2024/0847

5 Nelson Avenue, Monk Bretton, Barnsley, S71 2LY

Erection of two storey side extension and single storey rear and front extensions to dwelling

05 NELSON AVENUE, BARNSLEY. S71 2LY
PLANNING - ELEVATION - PROPOSED

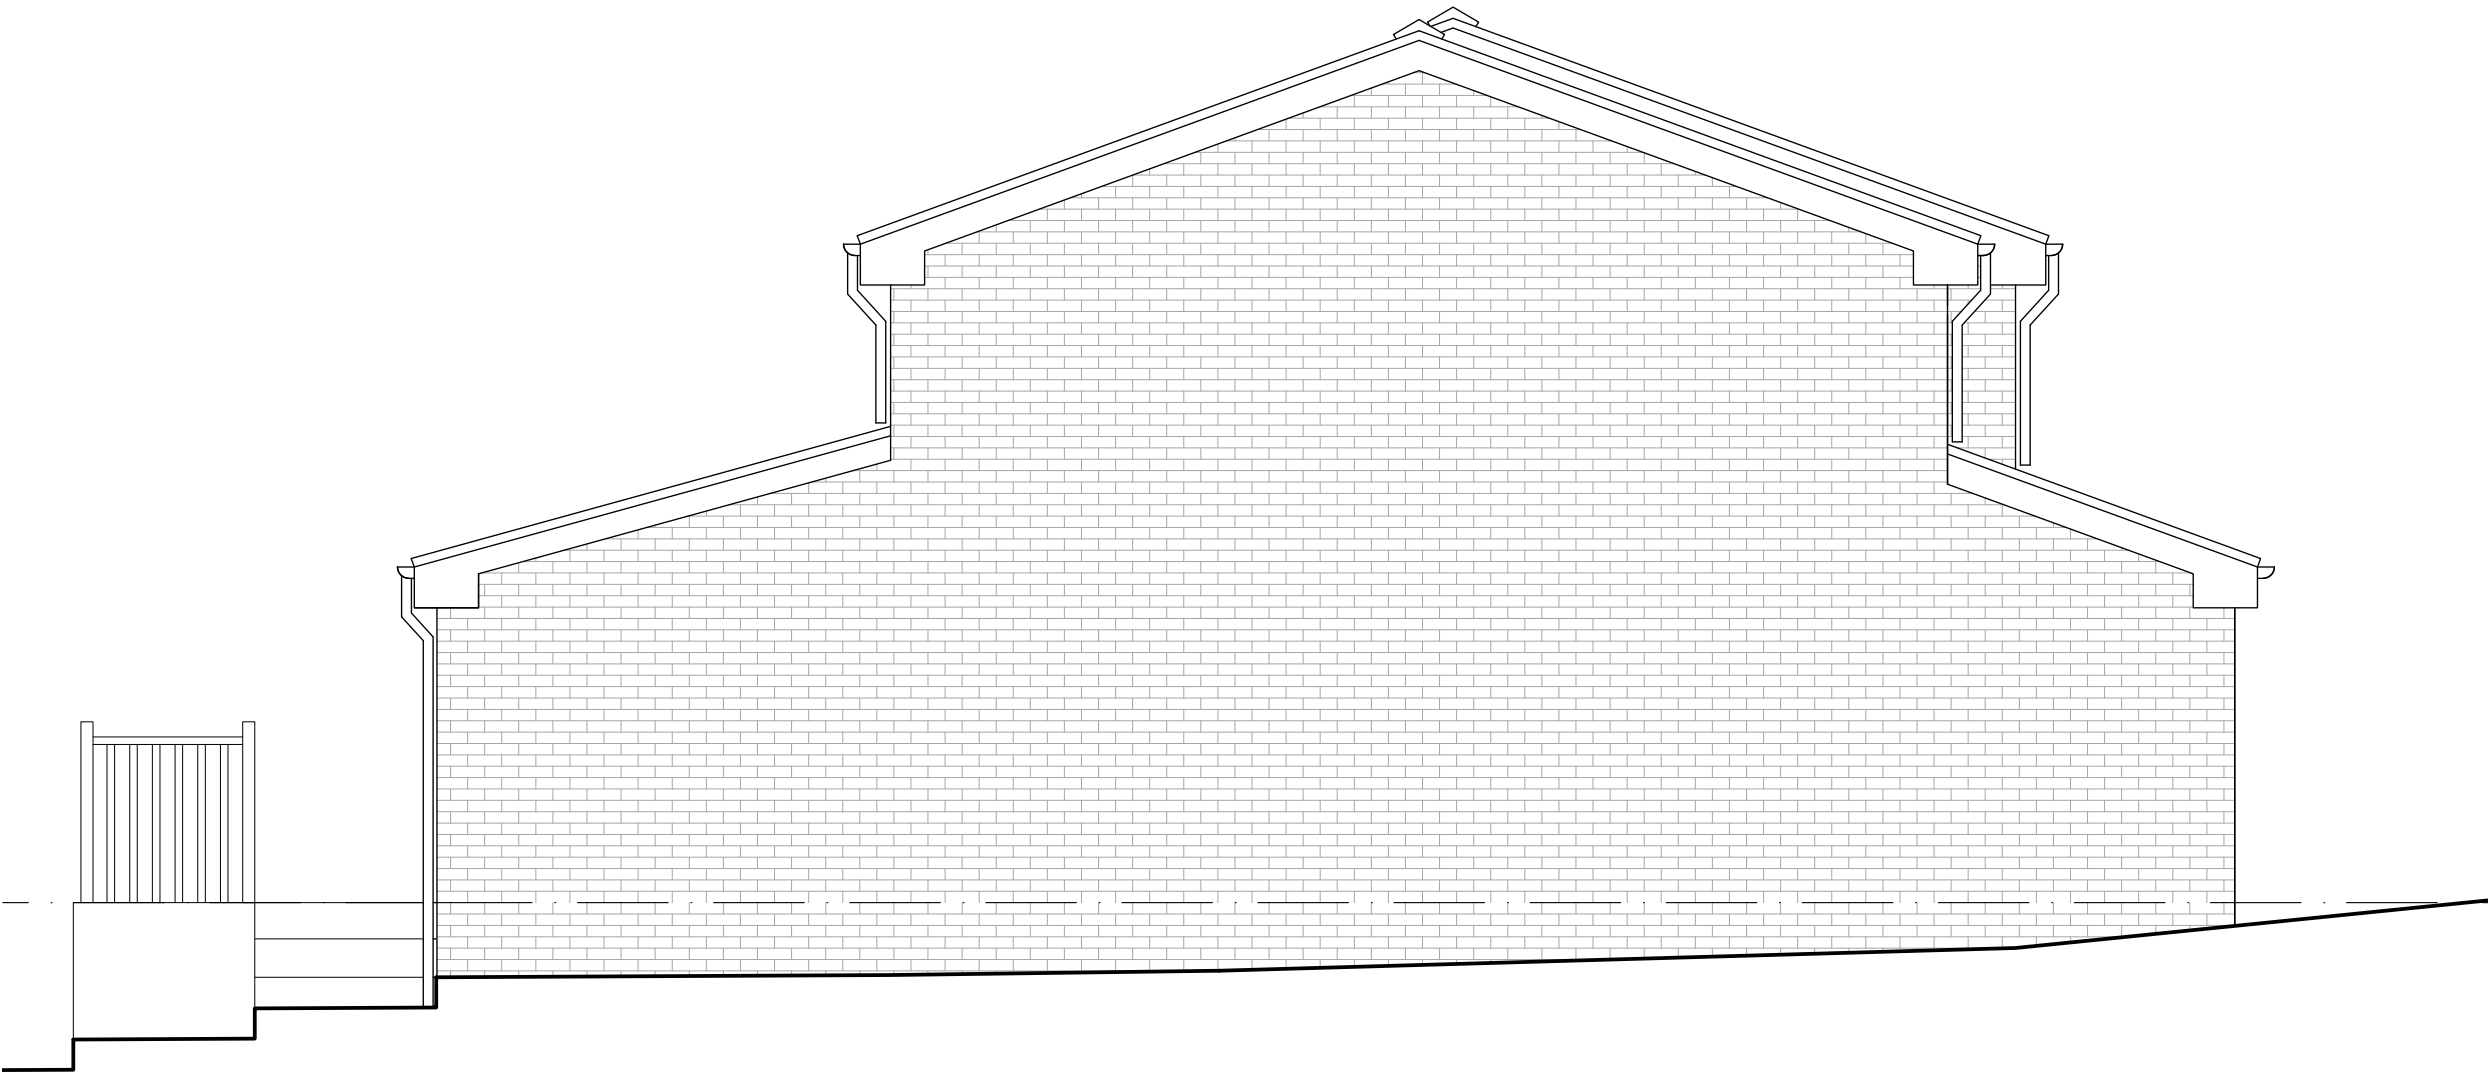
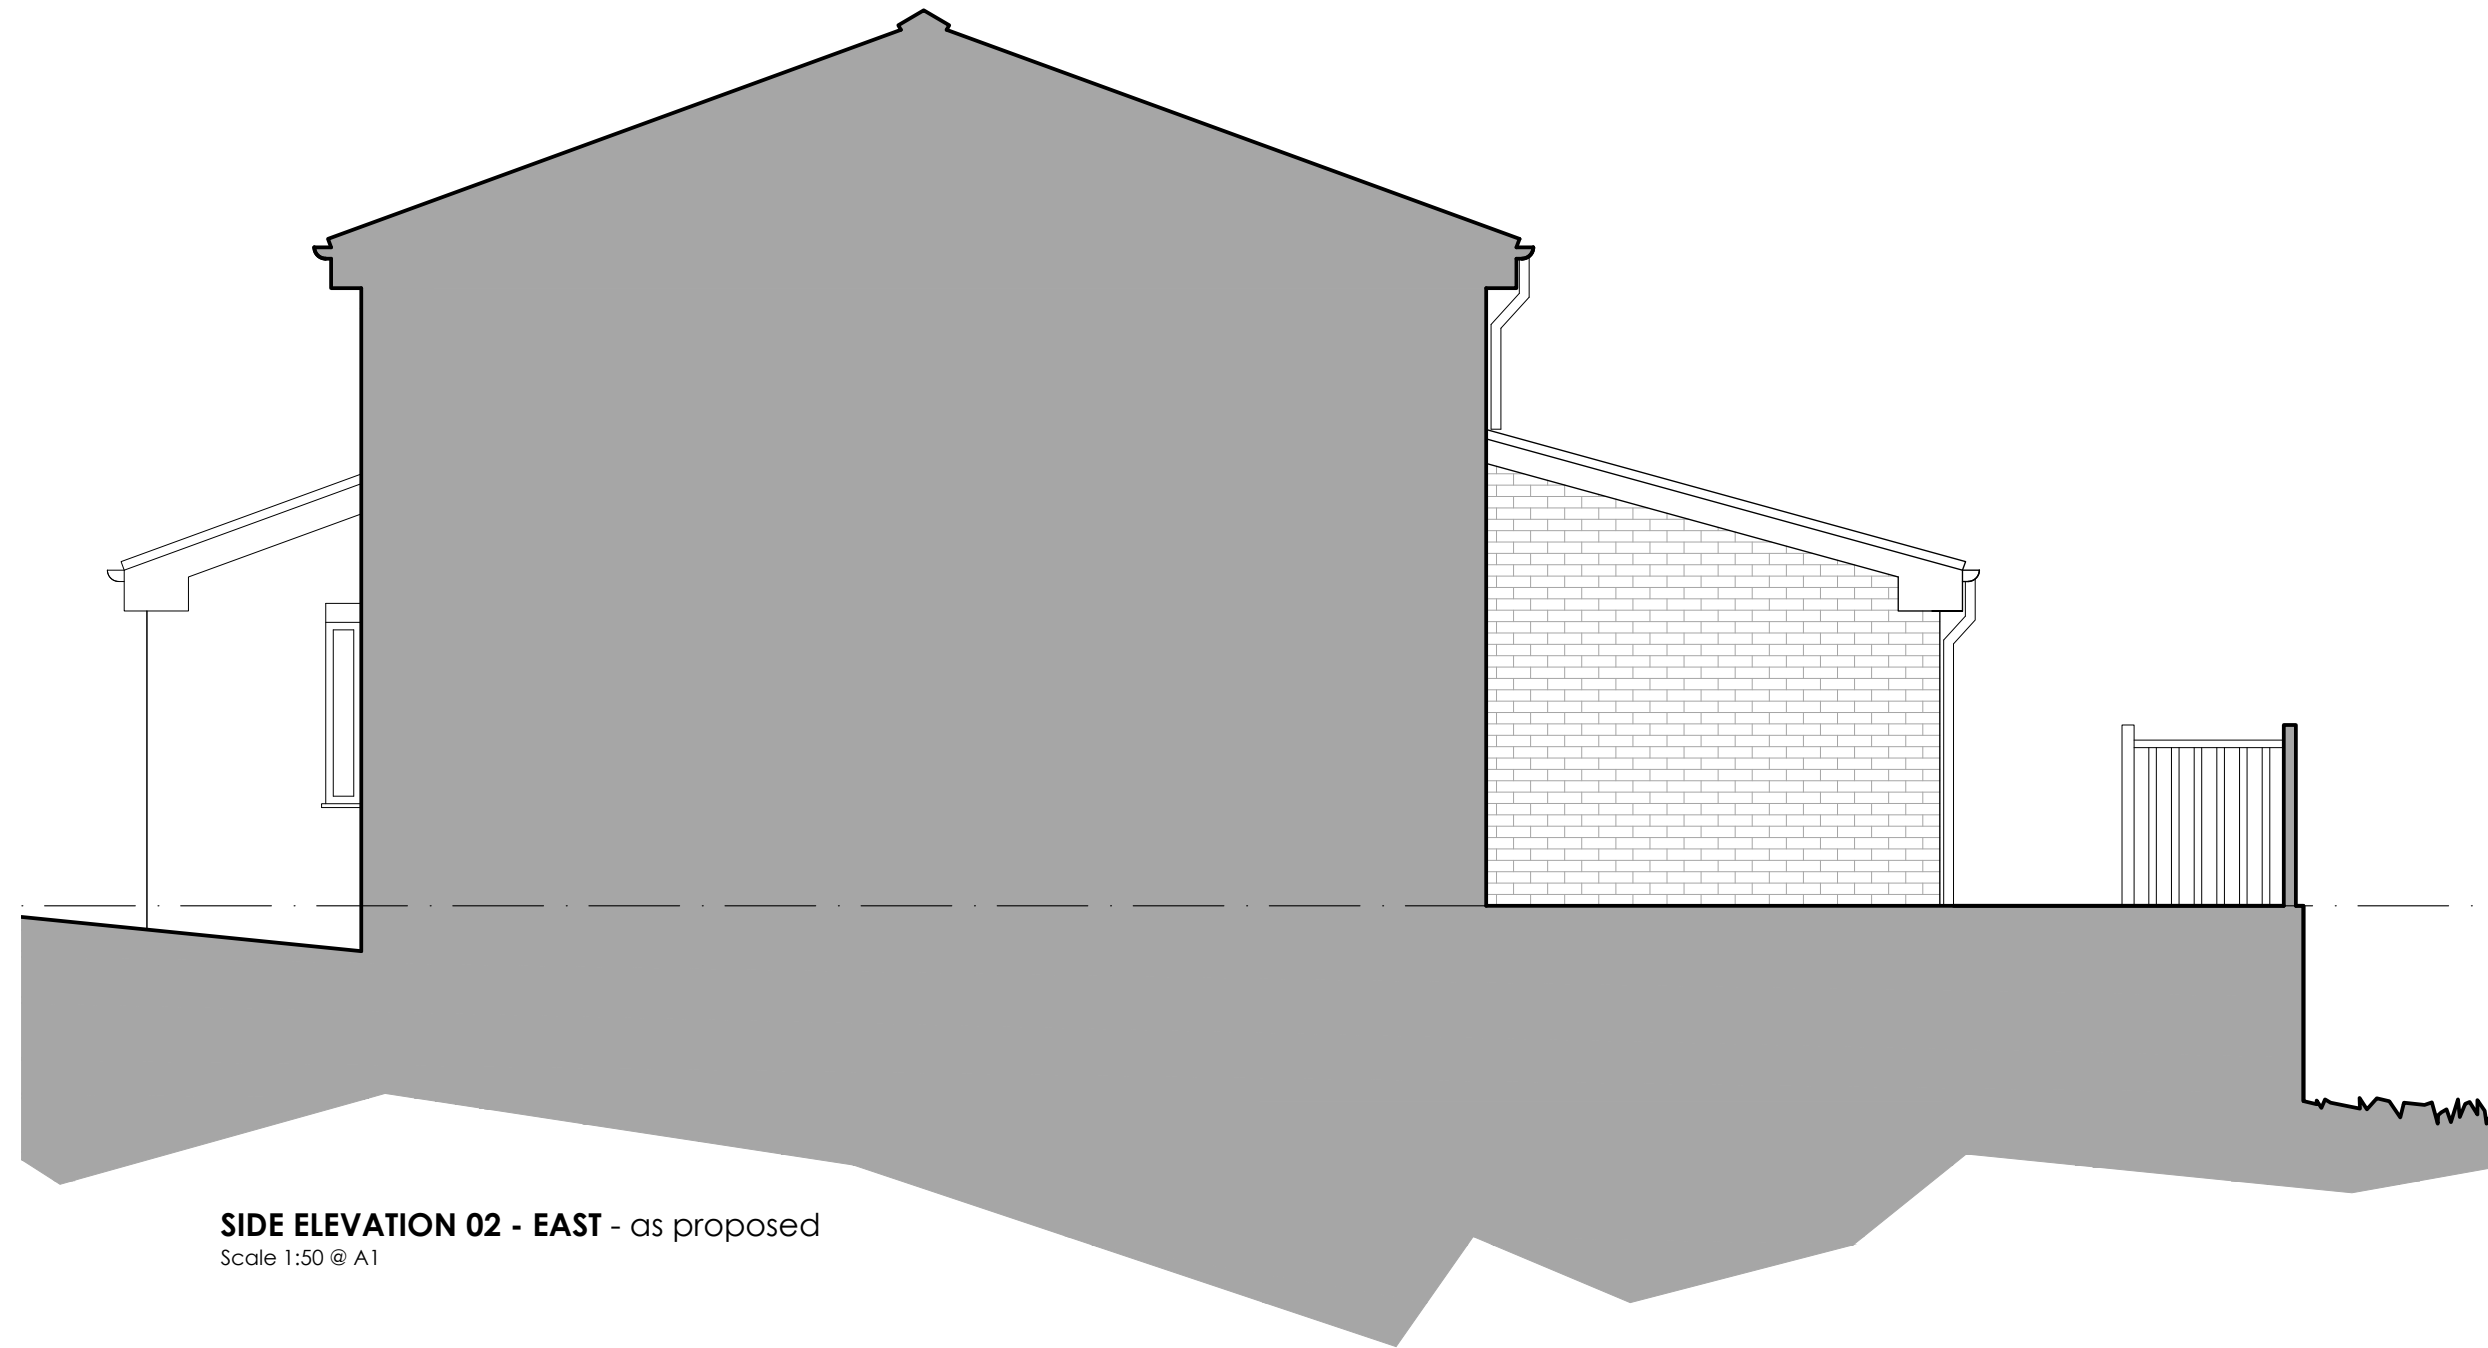
The rear elevation of the proposed two storey side extension details a window. This will service an en-suite and so will be conditioned to be obscured glass in order to protect the privacy of both the applicant and any surrounding neighbours.

The two-storey side extension benefits from a proposed setback of approximately 0.45 metre. Although this is slightly less than the desirable 0.5 metres this is considered acceptable. A lowered ridge height is also detailed. These two elements allow the proposal to be subservient to the existing dwelling. The proposal is also less than two thirds the width of the original dwelling and builds upon an existing garage extension therefore not increasing the existing width of the dwelling's footprint. A pitched roof detailed matching the roof form of the existing dwelling. This also improved the visual amenity of the property as an upgrade from the existing flat roofed garage extension.

The proposal to extend the front of the garage allows for an increased garage size which could be utilized for the storage of bins. This facility is not currently available to the property. The front extension benefits from a pitched roof element above the garage and porch which breaks up the dominance of the extension to the principal elevation. The proposed garage door and front door are of a similar size to the existing garage door and front door. This allows for the proposal to not dramatically change the character of the street scene. The proposed second storey window to the front of the dwelling matches the size of existing windows on the dwelling.

The rear elevation extension provides a pitched roof form, which although is not seen from the street is preferred. Rear Velux windows are detailed symmetrically to match the existing windows on the dwelling along with the proposed bifold doors and rear side extension windows.
